Re: Submission – OBJECTION to Modification Application MP06_0310-Mod-4

Emirates One&Only Resort, Wolgan Valley

Figure 3. Preferred flight paths.

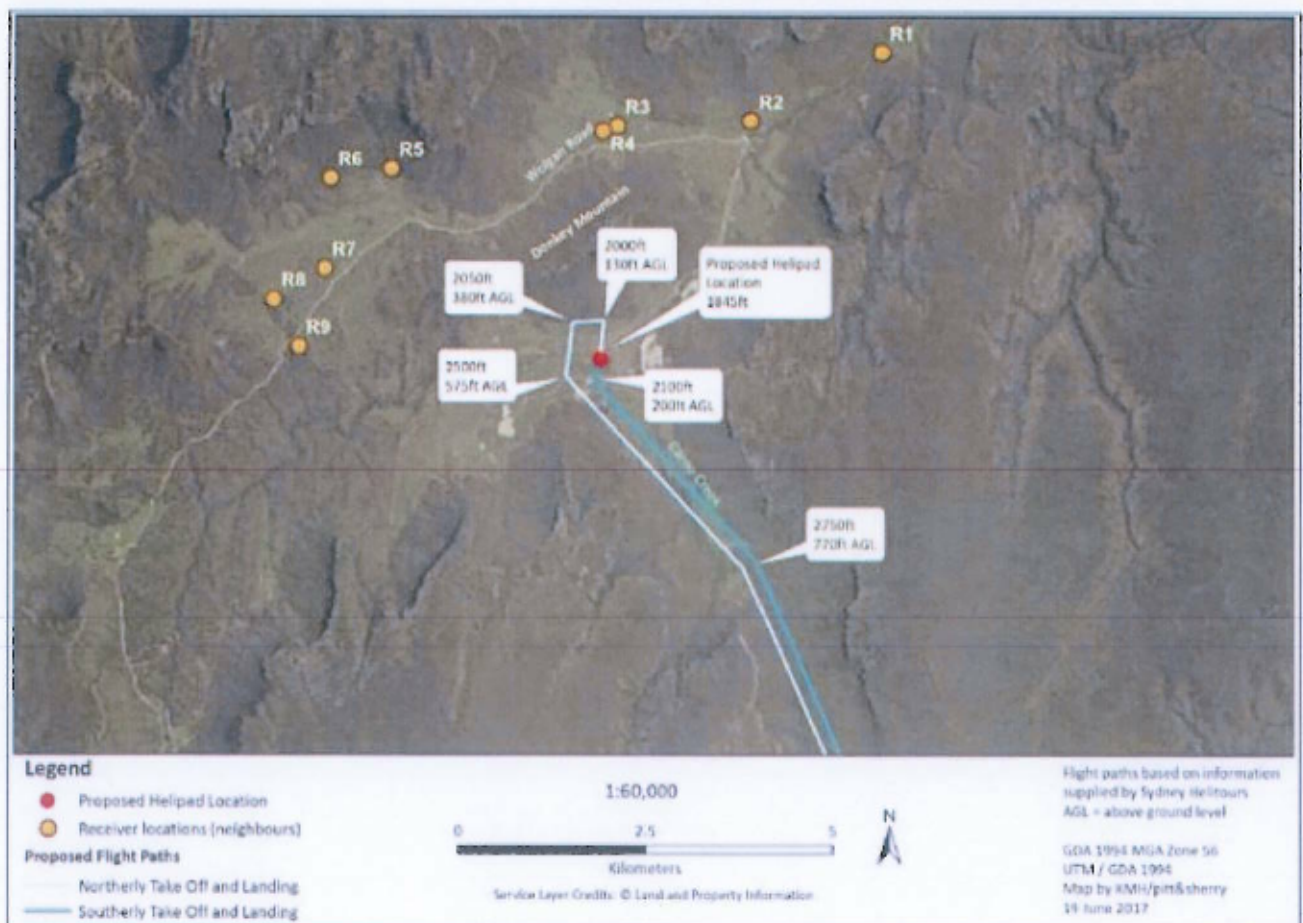
The proposed path routes south over Gardens of Stone National Park and Gardens of Stone State Conservation Area, a well-known destination for rock climbing, bushwalking and nature-based recreation (NSW NPWS, Gardens of Stone Visitor Guide). Every receiver R1–R10 in the noise reports (Wilkinson Murray 2017; RWDI 2023; Bridges Acoustics 2020) is a residence. No receiver is placed at a crag, a walking track, a campsite or a lookout. Recreational park users are simply not represented. In rock climbing, clear communication between climber and belayer is absolutely essential for the safety of both parties, and of anyone nearby. Excessive noise in rock climbing areas poses a genuine safety risk. Beyond safety, it should go without saying that peace and quiet are fundamental to the appeal of outdoor recreation. Excessive noise of any type is an unacceptable impact to the amenity of this user group. Adventure tourism in the greater Blue Mountains region will be affected, and those affects will go beyond the success of a single hotel.

The southern path was chosen to avoid Carne Creek and the approved Pagoda Walk corridor, but it now routes helicopters directly over the southern section of Gardens of Stone NP and the SCA. Table 6 of the Modification Report itself shows 729 ha of park receiving L_{Amax} 65–80 dB(A) per event, including 37.5 ha at 75–80 dB(A). My own acoustic modelling (ISO 9613) shows the nearest crag in the Carne Creek climbing area will receive 60–64 dB(A) L_{Amax} **per event** under either the approved or the proposed path – more than 10 dB above the NPI passive-recreation criterion (about twice as loud).

- (i) A fresh noise impact assessment is prepared that nominates and models all recreational receivers in the area, including Carne Creek climbing areas, the Pagoda Walk corridor and representative lookouts in Gardens of Stone National Park and State Conservation Area;

- (ii) The assessment applies the NSW NPI 2017 Table 2.2 amenity criterion (50 dB(A) L_{Aeq}, national park) with the +5 dB tonal/impulsive adjustment under NPI Fact Sheet C;
